Meeting:	Hillingdon Planning Committee	
Date:	4 September 2025	Time: 7:00pm
Venue:	Committee Room 5, Civic Centre

ADDENDUM SHEET

Item: 7	Location: 35 Brookdene Drive, Northwood
<i>Amendments/Additional Information:</i>	<i>Officer Comments:</i>
1) Drawing ref. CWLD-DSSA-BD-2480-01 Rev B replaced by Rev C and Conditions 2 (Approved Plans) and 8 (Landscape Plan Implementation) updated accordingly. 2) Amend reference in Condition 16 to the 1995 version of the GPDO to the 2015 version. 3) Since the completion of the Committee Report two additional representations providing supplementary objections and observations (these neighbours have previously commented) has been received from neighbouring residents. These representations raised the following summarised matters: <u>Representation 1</u> a) Misrepresentation of the existing building footprint. This neighbour believes that the existing conservatory should not be considered either part of the main building or as part of the existing building footprint. Requests that the separation from No. 34 Brookdene Drive and footprint of replacement dwelling is in accordance with the original plot arrangement (i.e. before the existing conservatory

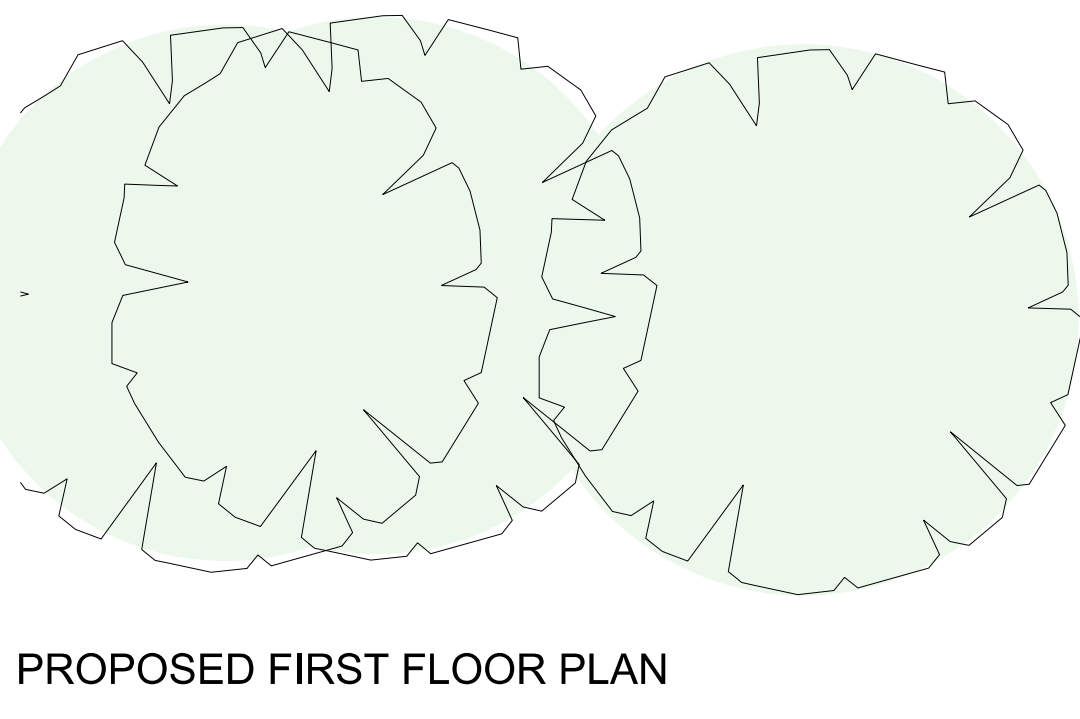
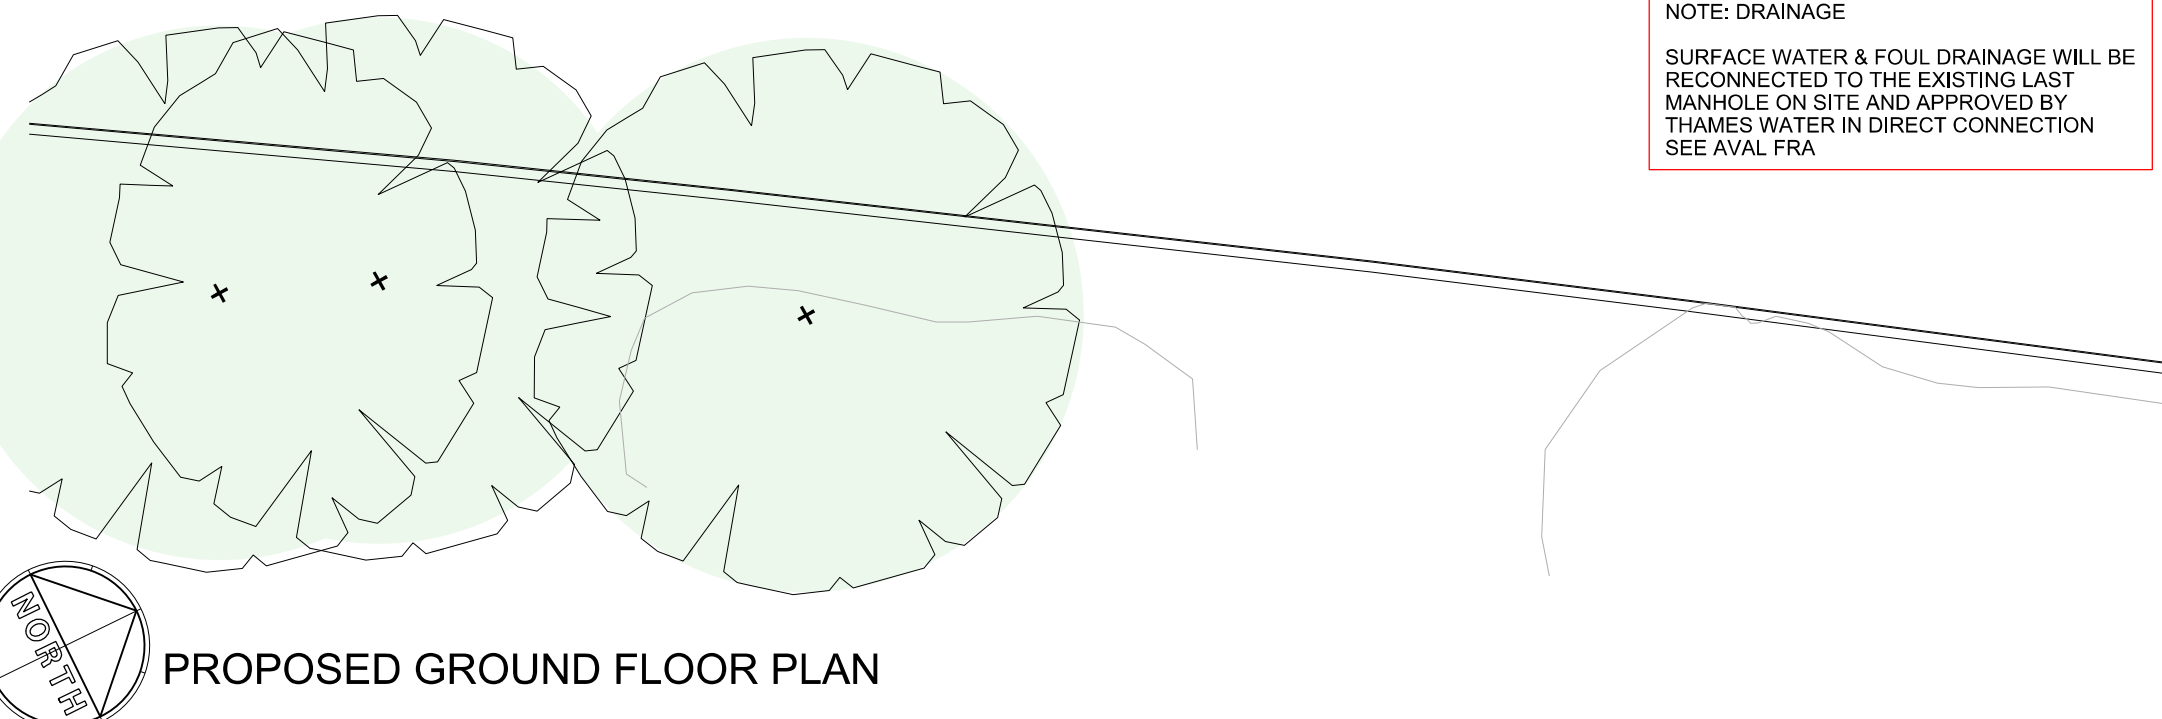
- conditioned to control the location, specification and operation of the ASHP.
- g) The bin storage has been relocated away from No. 34 Brookdene Drive but is also shown adjacent to this neighbouring property.

In respect to the first-floor element, as the centre of the French doors is set-back further from the shared boundary than the first-floor window (45-degree line depicted on plans from this neighbouring window), the proposal would meet this 45-degree line in plan form.

g) Amended plans have been received to remove the proposed bin store adjacent to the boundary with No. 34 Brookdene Drive. h) The scale and appearance of the proposal is discussed in paragraphs 7.10 - 7.18 of the Committee Report and considered acceptable. i) The proposed boundary treatment location is within the site curtilage, and the visual impact is discussed in paragraphs 7.20 - 7.23 of the Committee Report and considered acceptable. j) The potential residential amenity impact on the properties across the road from the site is discussed in paragraph 7.36 of the Committee Report. This is considered acceptable given the separation distance from the intervening highway. k) Highways safety impacts of the proposed crossover are discussed in paragraphs 7.43 and 7.44 of the Committee Report and considered acceptable. Condition 22 requires the maintenance of compliant pedestrian visibility splays. l) The proposed parking quantum complies with London Plan policy requirements and is acceptable. This is addressed in paragraph 7.46 of the Committee Report. m) Condition 15 prevents the existing outbuilding / garage from being used as anything other than for domestic purposes incidental to the enjoyment of the approved dwellinghouse. This is addressed in paragraph 7.4 of the Committee Report.

PROPOSED FRONT ELEVATION (NORTH)

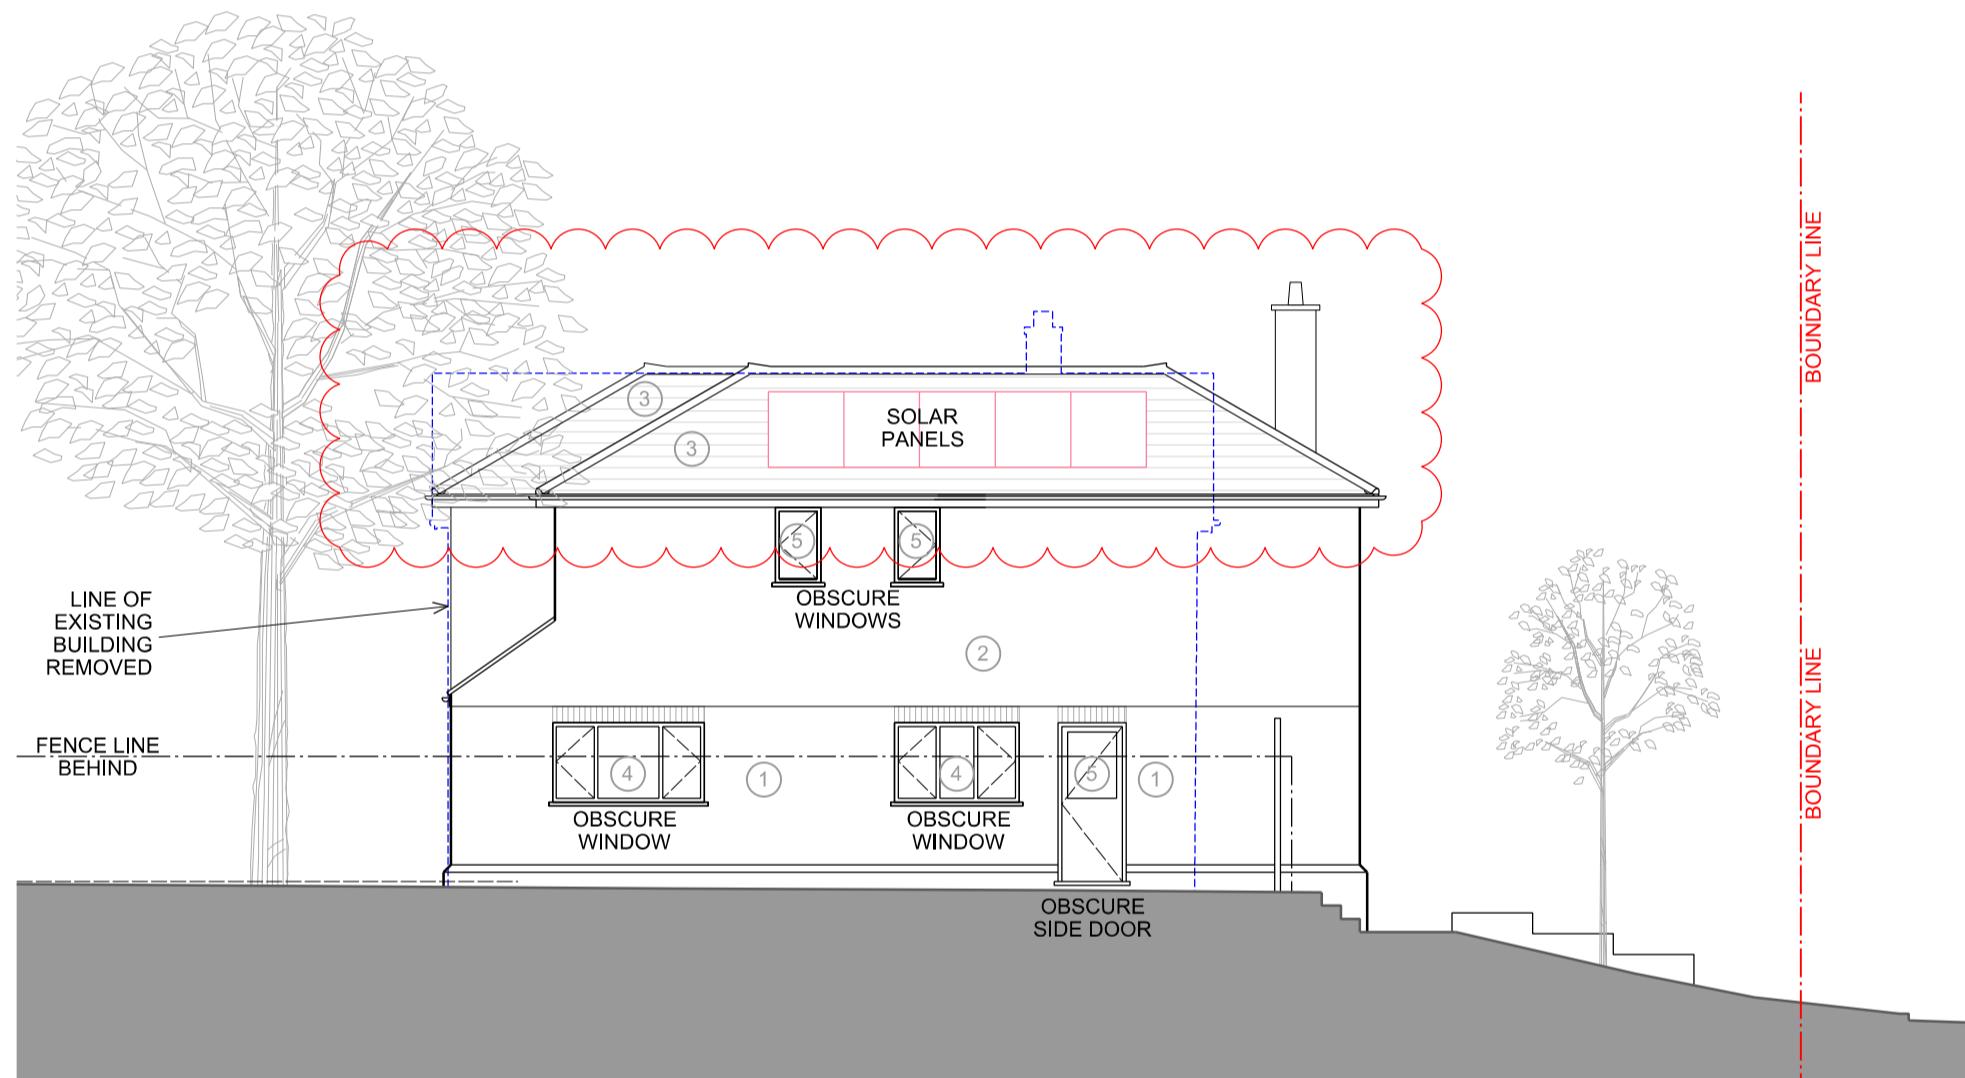
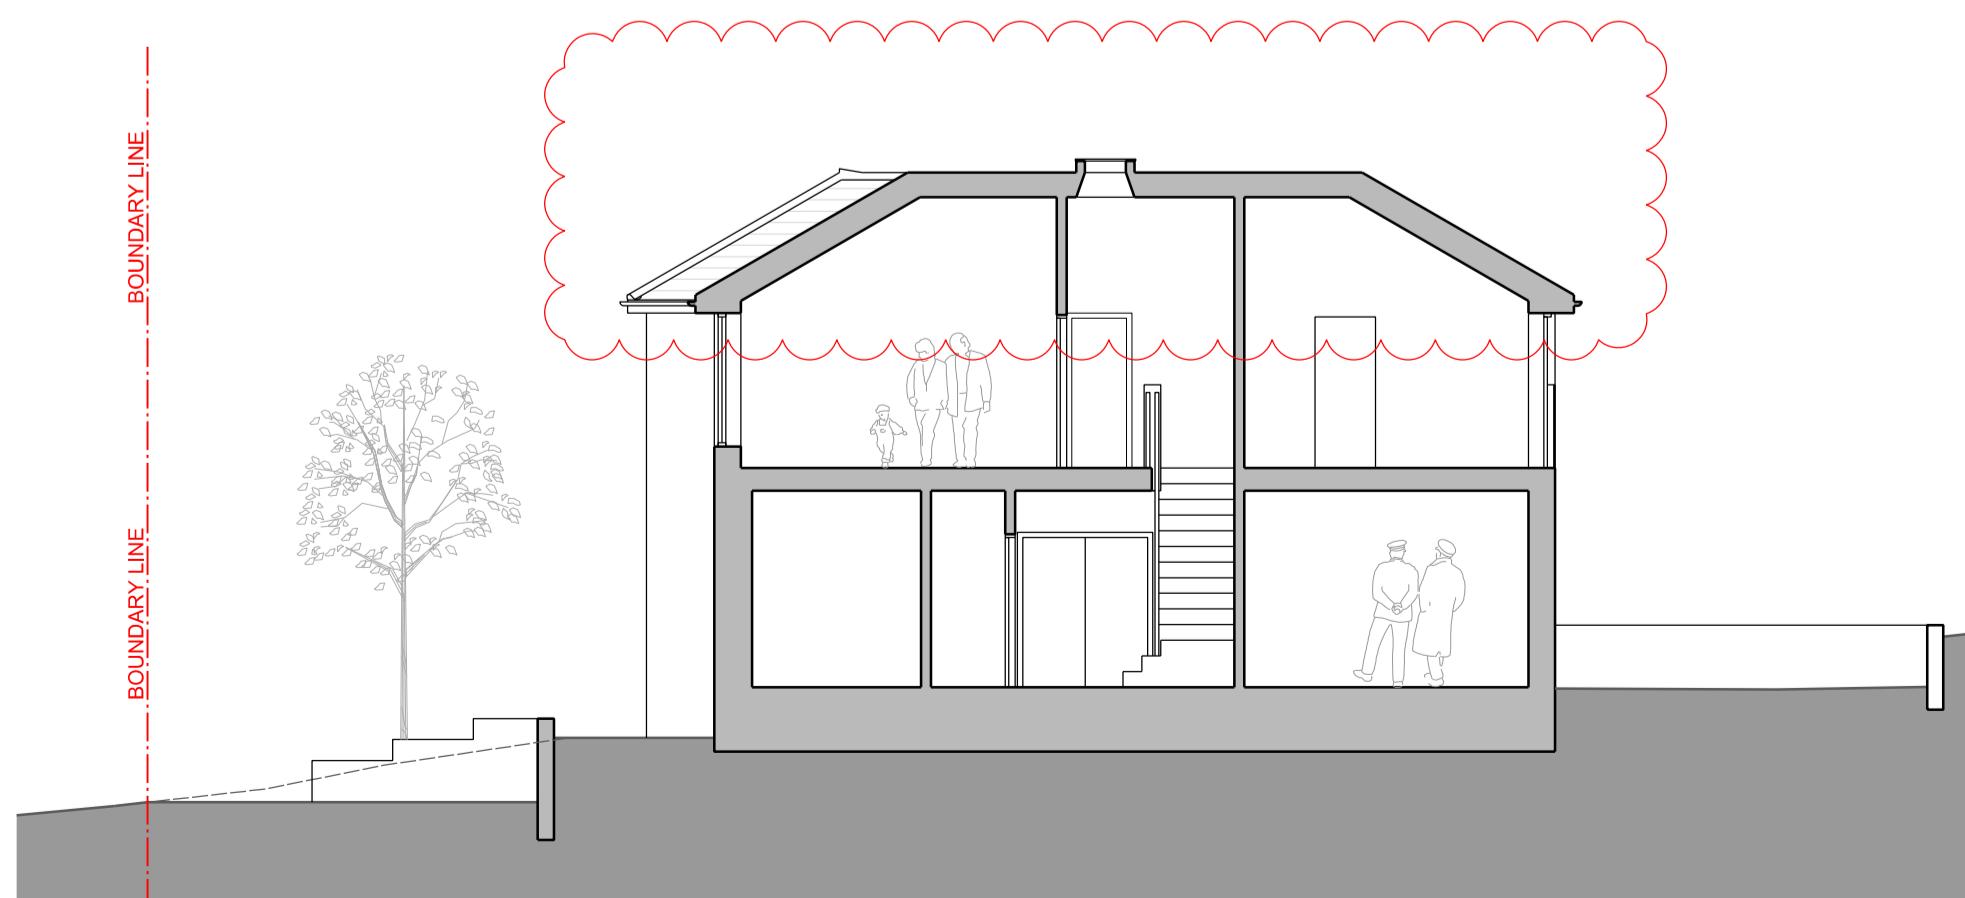
Condition 5 requires obscure glazing for side elevation windows facing No. 34 Brookdene Drive.

- d) There are numerous properties within Brookdene Drive that have side elevation windows, including the existing application site. The separation distances between property side boundaries also vary. The proposed development would maintain a separation distance of a minimum 1.2m from the shared property boundary.
- e) Sunlight and daylight matters are addressed in paragraphs 7.27-7.30 of the Committee Report and are considered acceptable.
